# CITY OF ALBUQUERQUE

RE: **Jiffy Lube Expansion**  
**8305-8313 Menaul NE**  
**Grading Plan Stamp Date: 7/23/19**  
**Drainage Report Stamp Date: 7/23/19**  
**Hydrology File: H15D068**

Based on the submittal received on 7/24/19, this project cannot be approved for Plat or Site Plan until the following are corrected:

\\NASO\2018\2018016 Jiffy Lube Menaul & Wyoming.dwg Site Plan -- Administrative\2018016\_GR.dwg Sep 04, 2019 - 9:22am

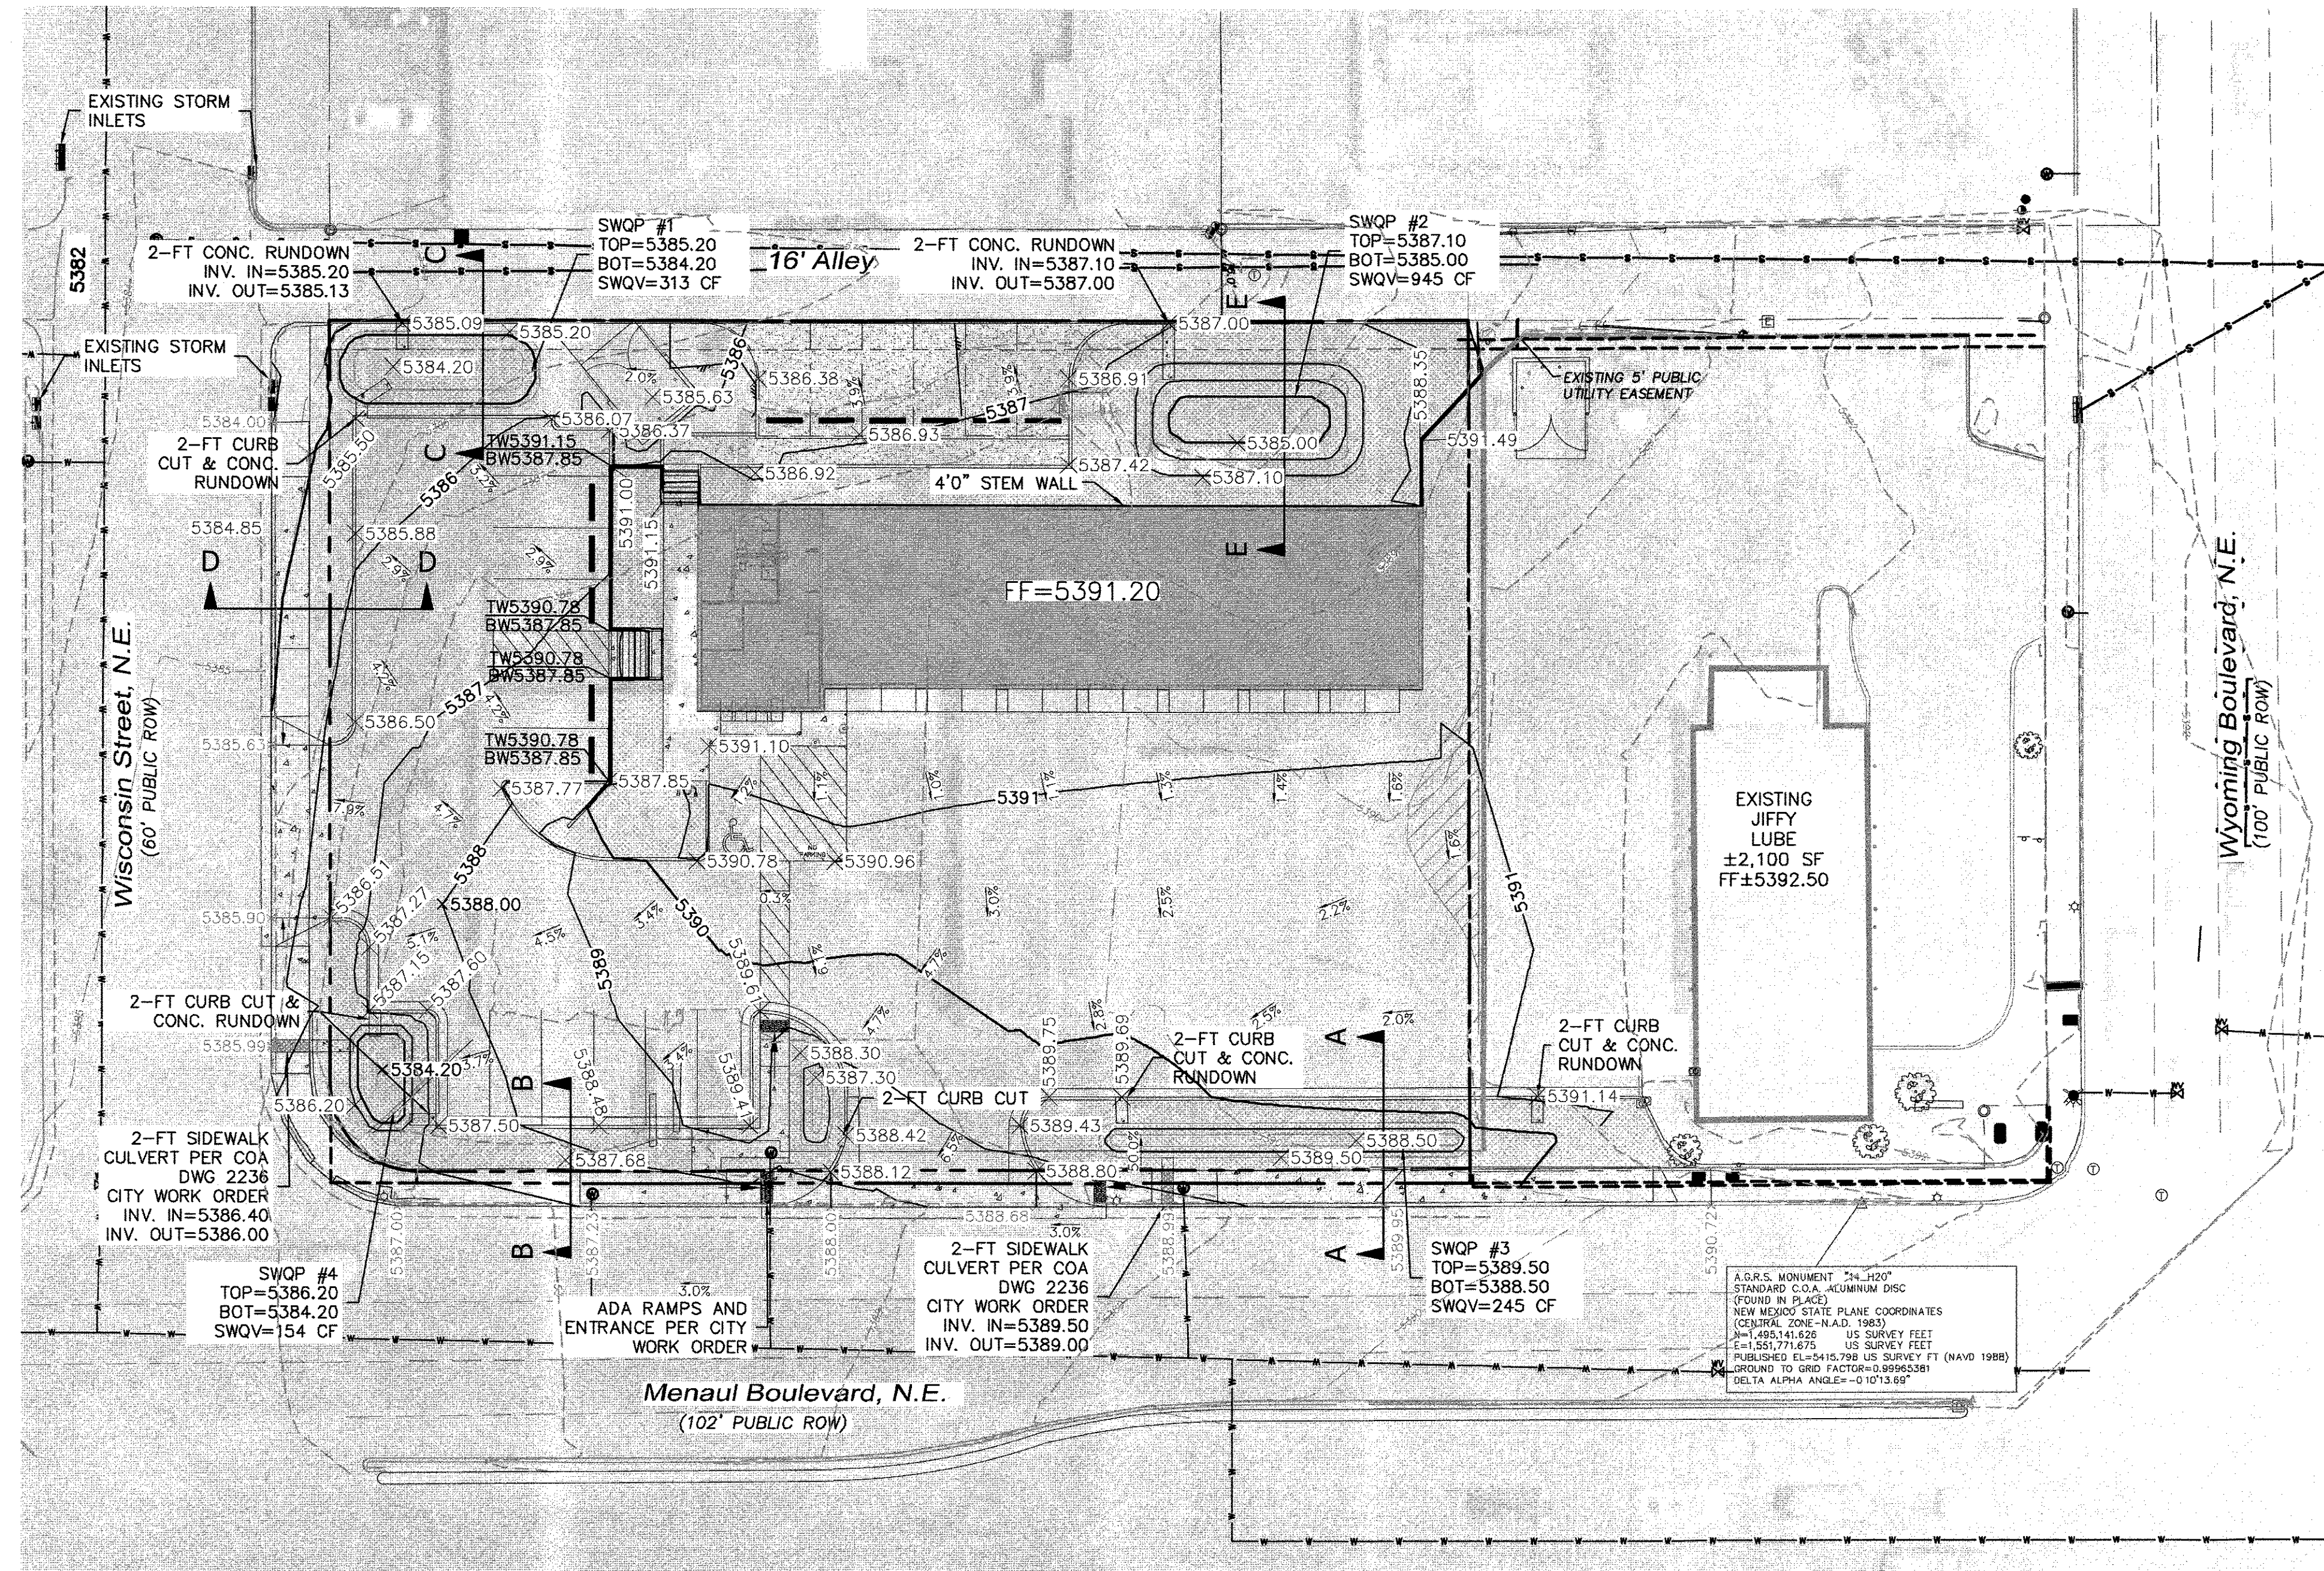
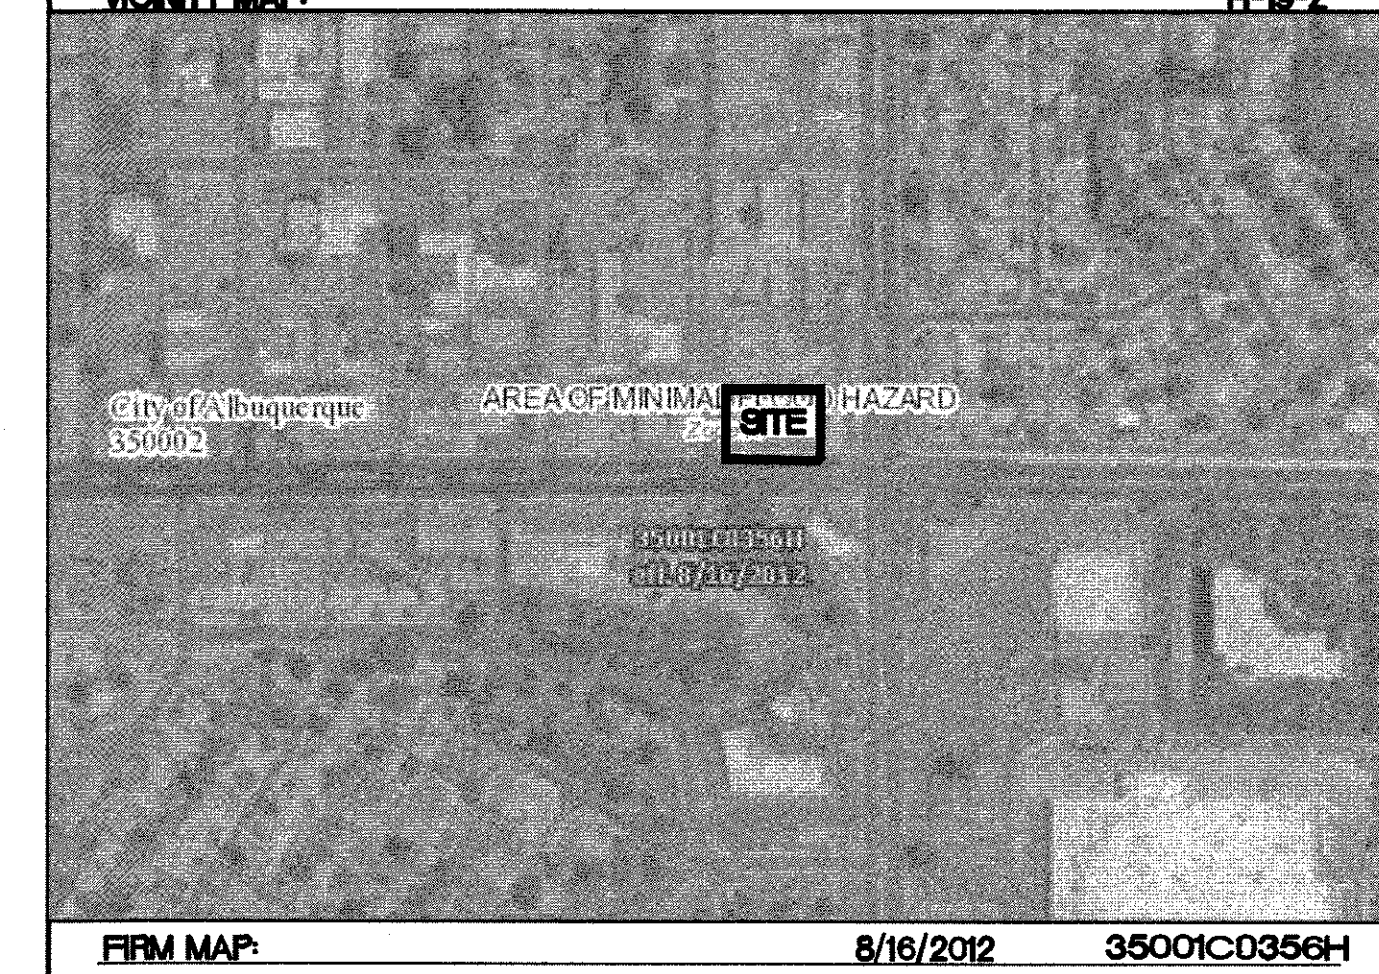
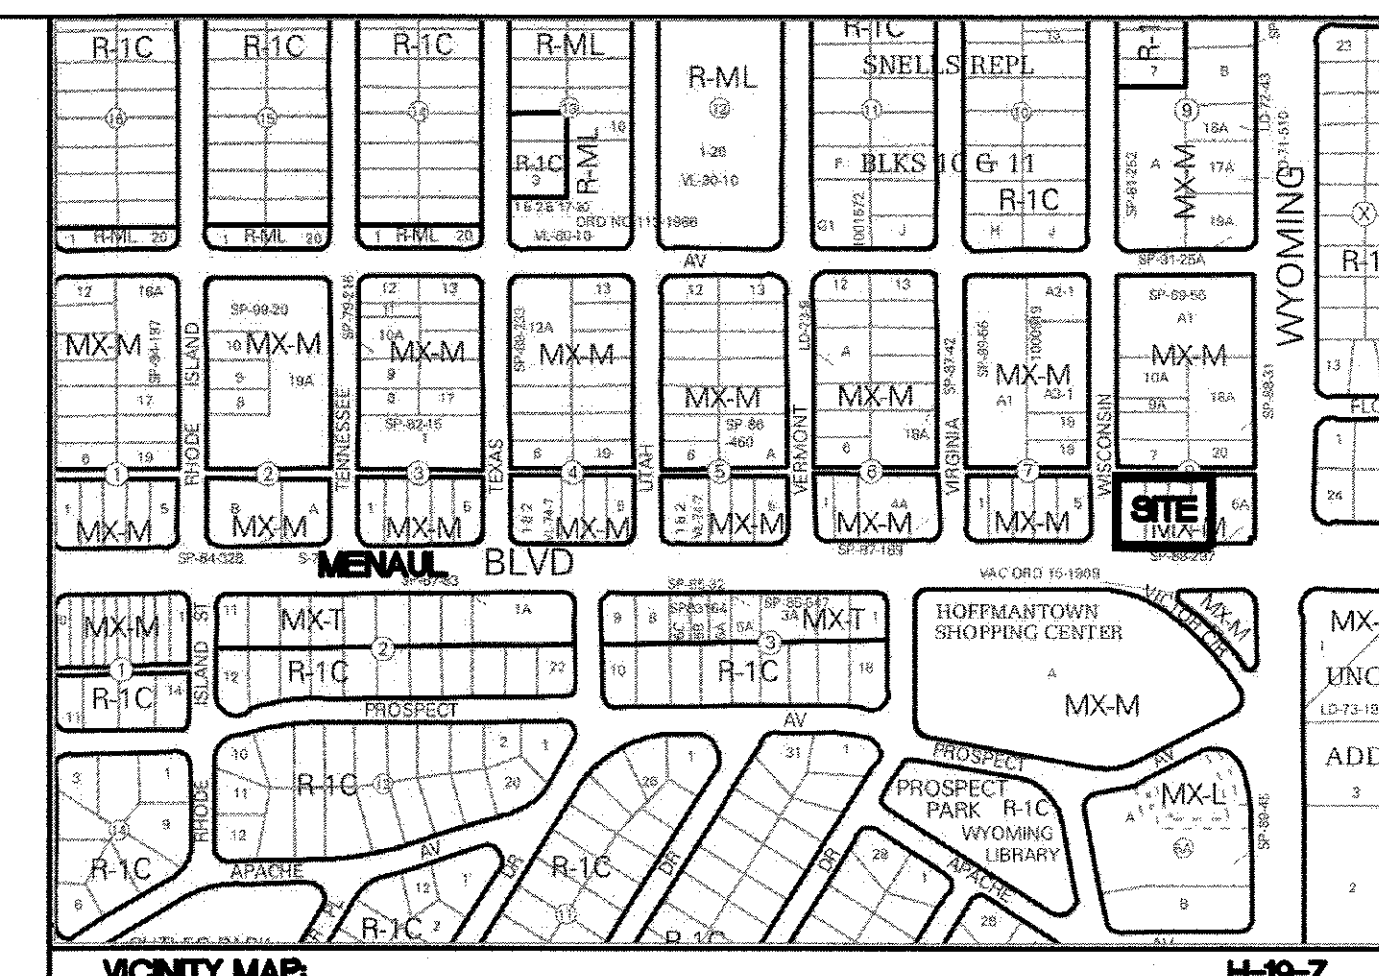
1. Remove the SO-19 notes and language and replace with "to be built by Work Order" or similar.
2. List the sidewalk culverts on the infrastructure list; correct the InvertIn elevations too.

4. SWQP 3 crosses lot lines. Either locate it on just one property, or two easements (or covenants) will be required, signed by each underlying property owner.

5. For automotive repair centers, demonstrate *control of oil from vehicle parking areas* per DPM Chapter 22.9.E, Table 1.
6. Identify the limits of repaving and new building. Stormwater quality requirements only need to be met for these areas. If unable to capture in the area of redevelopment, you can capture from elsewhere on your property to offset the bypass volume.

7. Please provide the SWQV calculations for each basin draining to each pond. The stormwater quality ponds need to be sized for the areas draining to them. As currently presented, payment in lieu of some management onsite will be required.

8. Around the driveways on Menaul and Wisconsin, how will flows be diverted into the ponds instead of simply flowing out the driveway?
9. Show all proposed walls and label clearly in plain view; add top wall/bottom of wall spot elevations. Provide sections through all external boundary walls showing proposed retaining walls, garden walls, property/ROW lines, existing and proposed grades. In accordance with DPM Ch.22, section 5 part B, grading and wall construction near the property line may not endanger adjacent property or constrain its use.
